**RE: Woodmen View RV & Boat Storage Pond As-Built Memo
8035 Vollmer Place, El Paso County**

The Woodmen View RV & Boat Storage pond facility was designed and constructed under County file #PPR03040. The Final Drainage Report and approved design plans were prepared by Calibre Engineering, Inc. in July 2010. Baseline Engineering has been requested by the owner of Woodmen View RV & Boat Storage to prepare the As-Built Record Drawings. Additionally, Baseline was tasked to respond to engineering comments from El Paso County's Final Acceptance Punchlist dated November 20, 2024. There were four items that were noted in the punchlist that deviated from the approved design plans:

WOODMEN VIEW STORAGE PLOT PLAN AS-BUILT CONSTRUCTION DRAWINGS

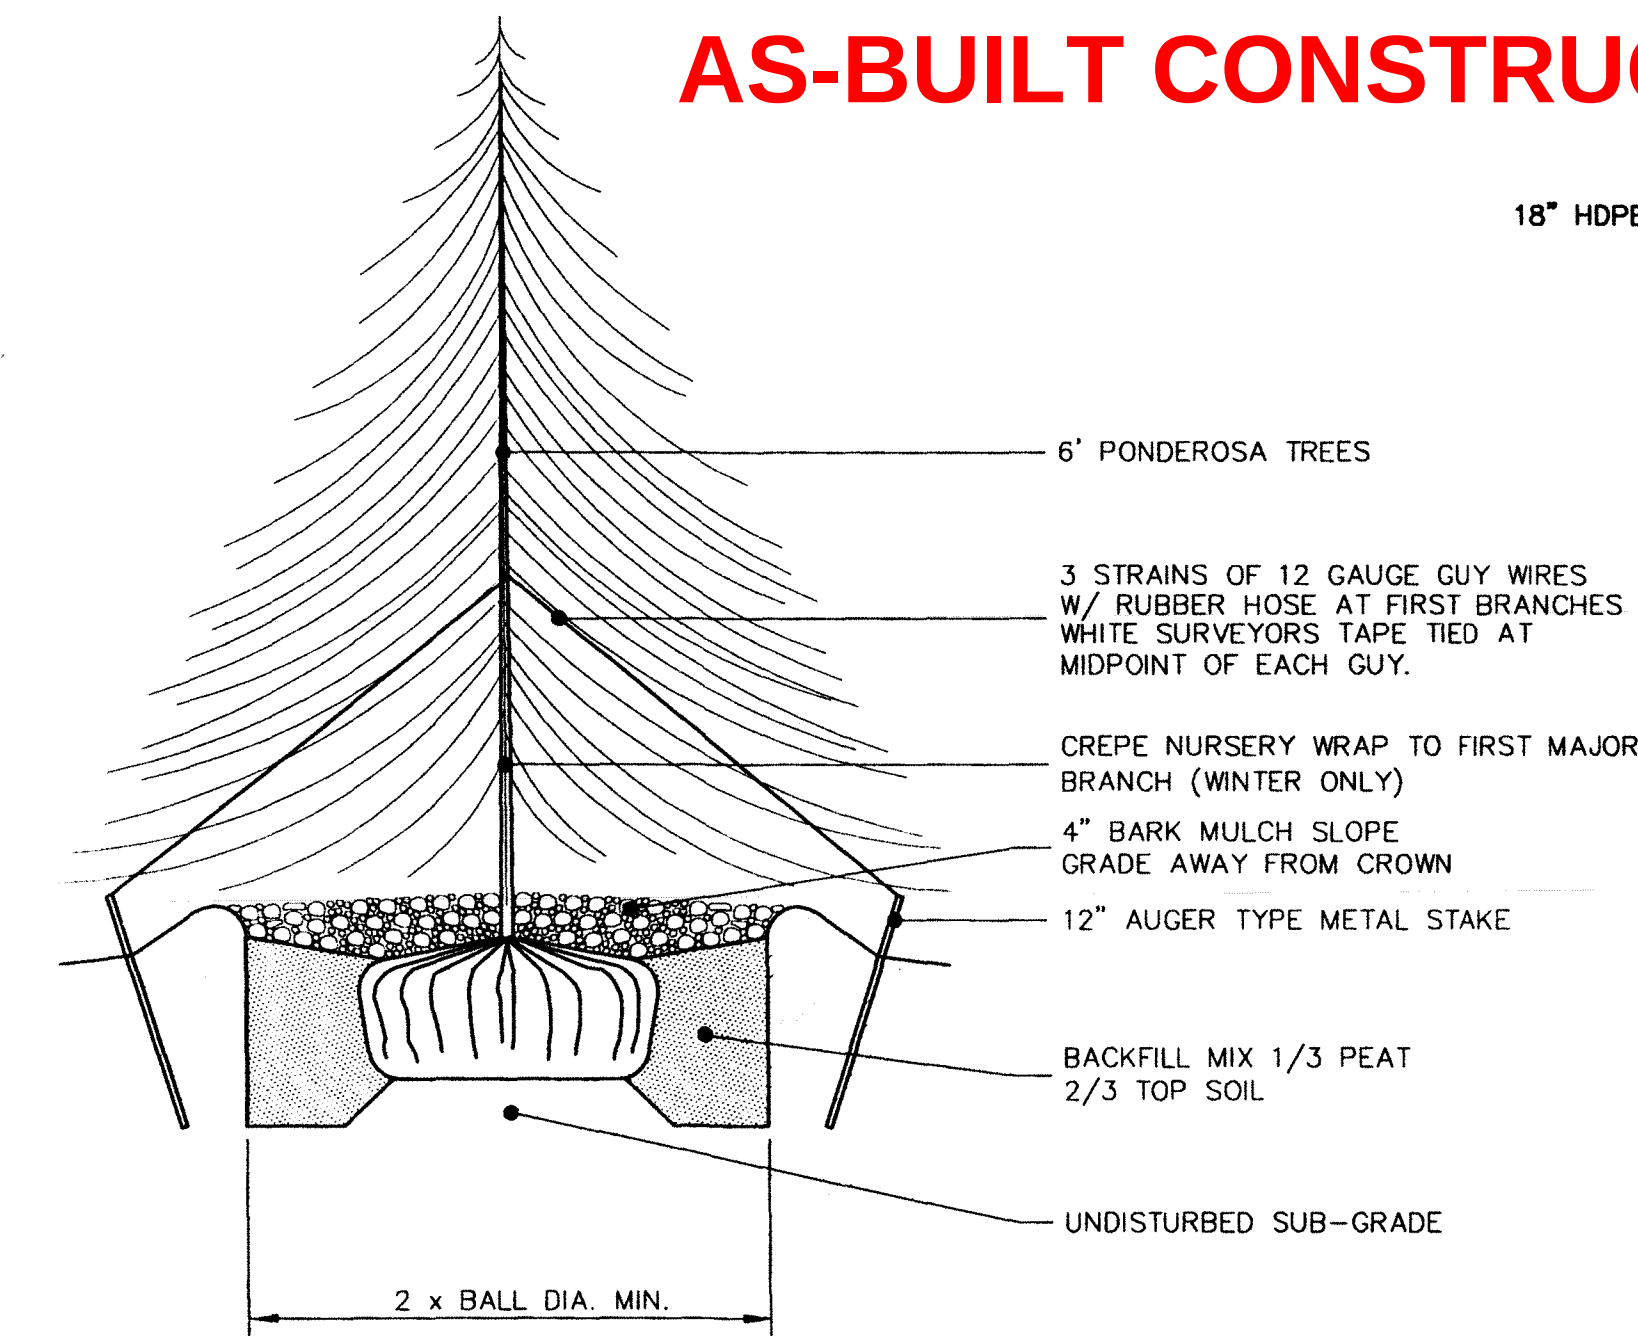
"Swale along NW site boundary was designed as a grass lined swale (reference section A-A detail on plan sheet #3) but was installed as a riprap lined swale. Confirm with your project engineer that this change from the plans is acceptable and then reflect the change on the as-builts. Additionally, consult with your engineer to confirm dimensions of swale (width and depth) are acceptable. Reference Photo 1"

Riprap lining of the swale is acceptable and has been reflected on the as-built plans. The northernmost approximately 200 feet of the swale downstream of the culvert under Vollmer Place was evaluated and determined to be shallower than would be required to fully contain the calculated 100-year runoff event within the swale section. However, the swale continues to convey nuisance and more frequent storm events directly to the detention basin as intended.

During larger storm events that exceed the swale capacity, runoff is conveyed to the detention basin via controlled overland flow across the RV parking lot in accordance with the overall site grading plan prepared by Calibre Engineering. This drainage pattern ultimately routes all flows to the detention pond, maintaining the intended site drainage function.

The site has operated in this configuration since construction in 2010 without reported adverse impacts to adjacent properties or downstream drainage facilities. As such, the drainage system continues to function as designed, with the parking lot serving as a secondary conveyance path during extreme storm events.

Consistent with typical site maintenance responsibilities, the owner remains responsible for maintaining and repairing the parking lot surface if localized flooding occurs during these larger events.

Based on the above, the swale configuration as constructed is acceptable from a drainage standpoint and continues to direct runoff to the approved detention facility.

POND AS-BUILT WOODMEN VIEW STORAGE

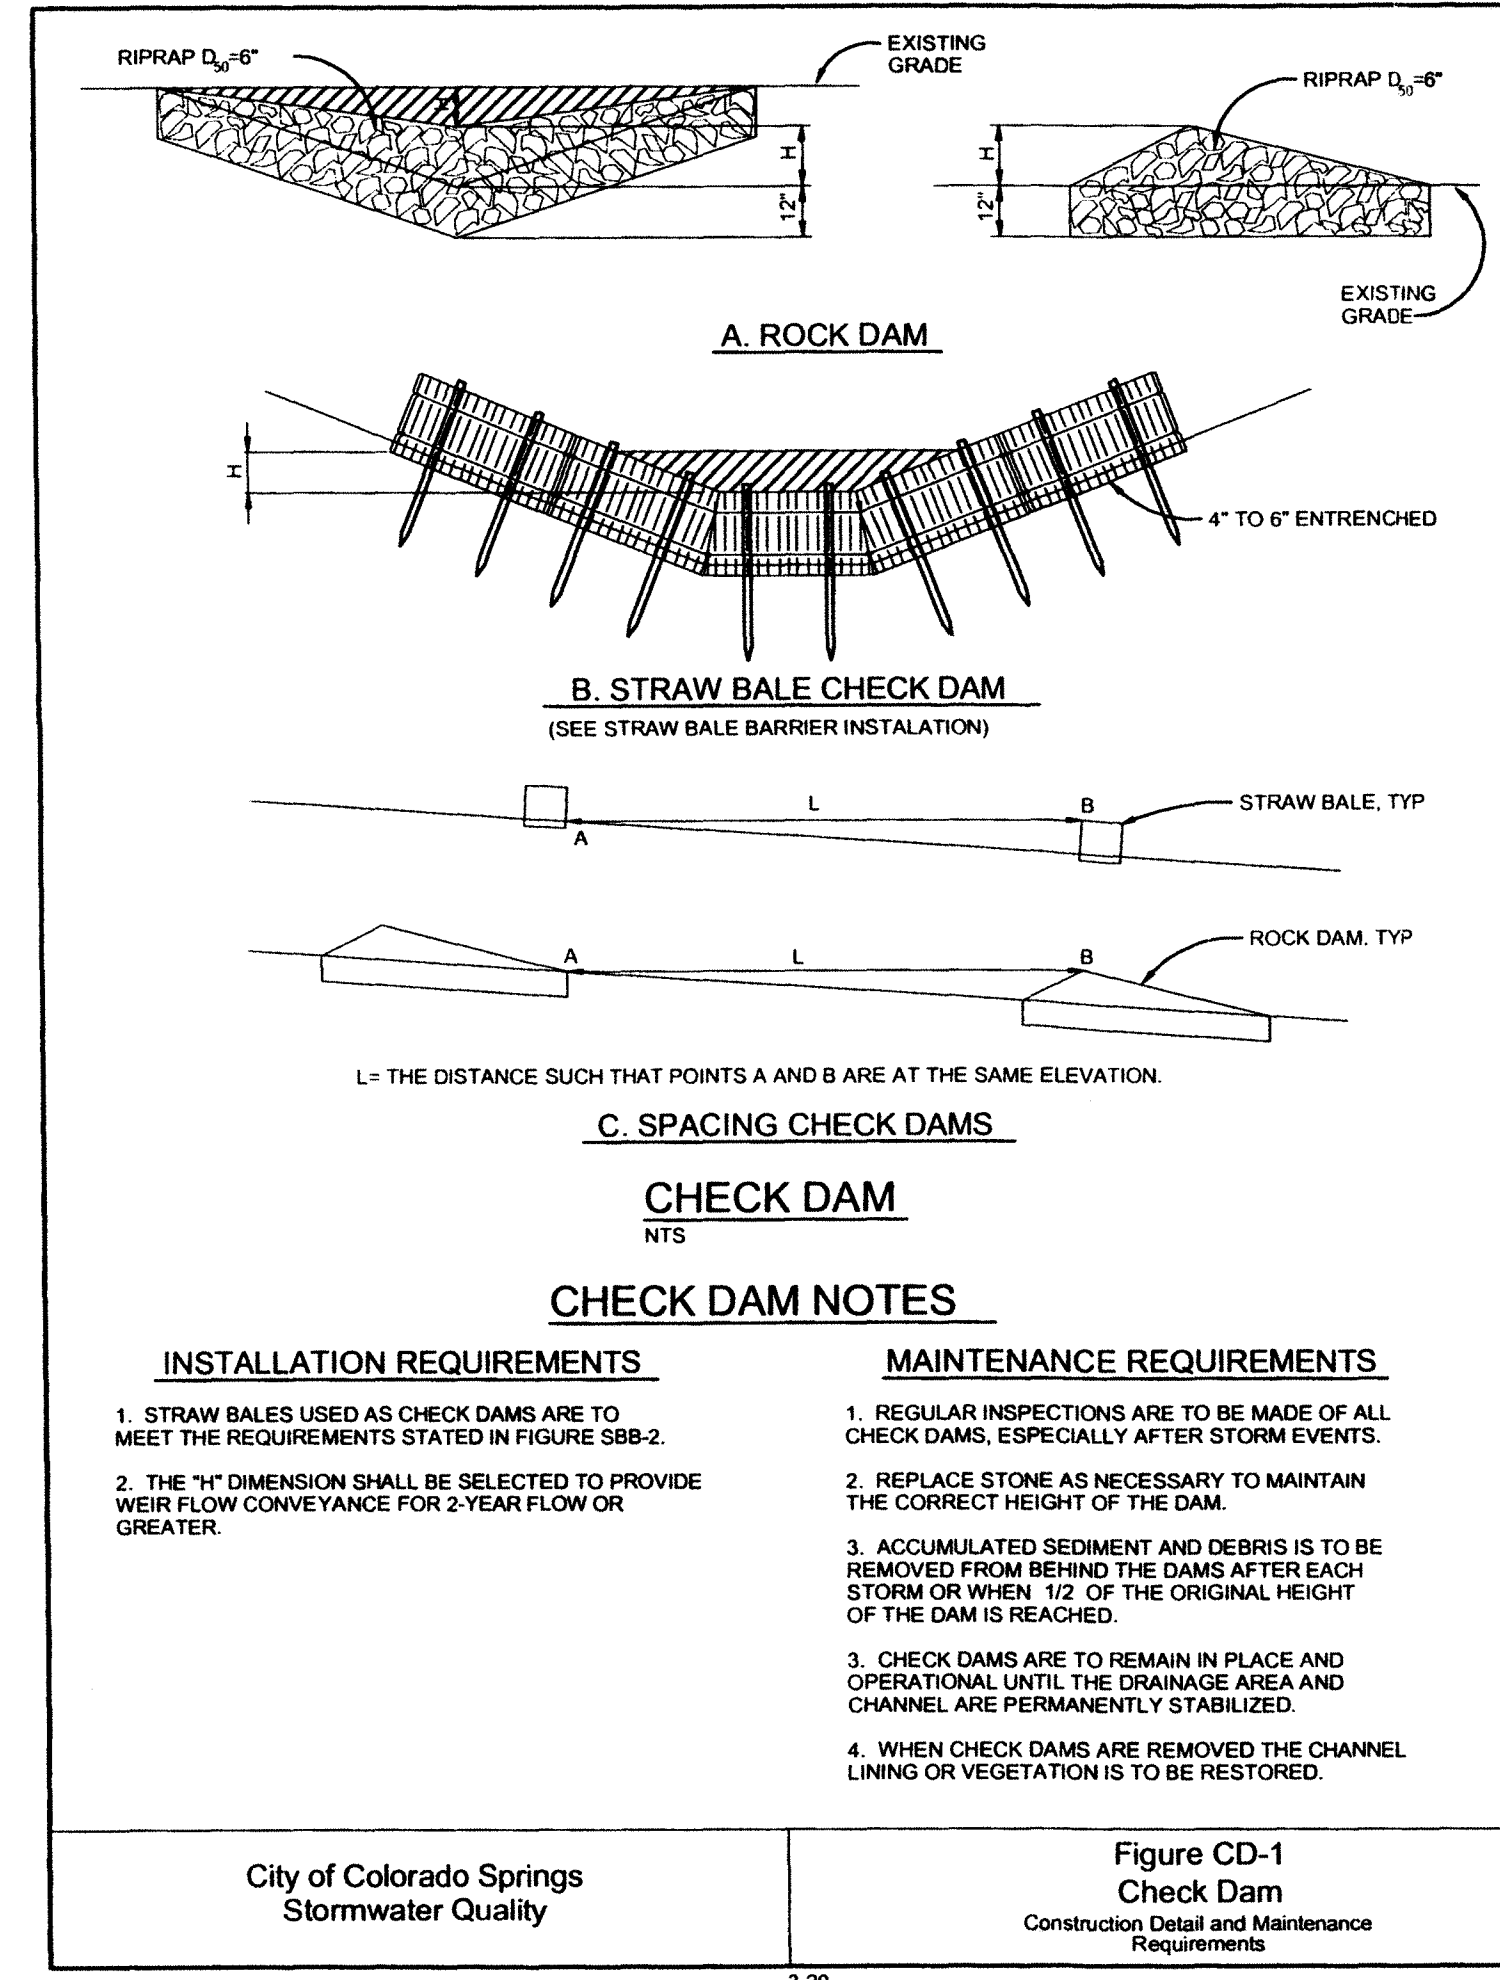
“Riprap along concrete trickle channel on W side of EDB is not shown on approved plans. Confirm with your project engineer that this change from the plans is acceptable and then reflect the change on the as-builts. Reference Photo 3”

“Riprap rundowns on N embankment at W end of EDB are not shown on approved plans. Confirm with your project engineer that this change from the plans is acceptable and then reflect the change in the as-builts. Reference Photos 17 & 18”

“Curb, inflow pipe, concrete apron, and riprap rundown at NE end of EDB are not shown on approved plans. Confirm with your project engineer that this change from the plans is acceptable and then reflect the change on the as-builts. Reference photo 19.”

Riprap along trickle channel edge is acceptable. Riprap has been added to the as-built plans.

Riprap along N embankment is acceptable. Riprap has been added to the as-built plans.

Curb, inflow pipe, concrete apron and riprap rundown is acceptable. Updates have been added to plans.
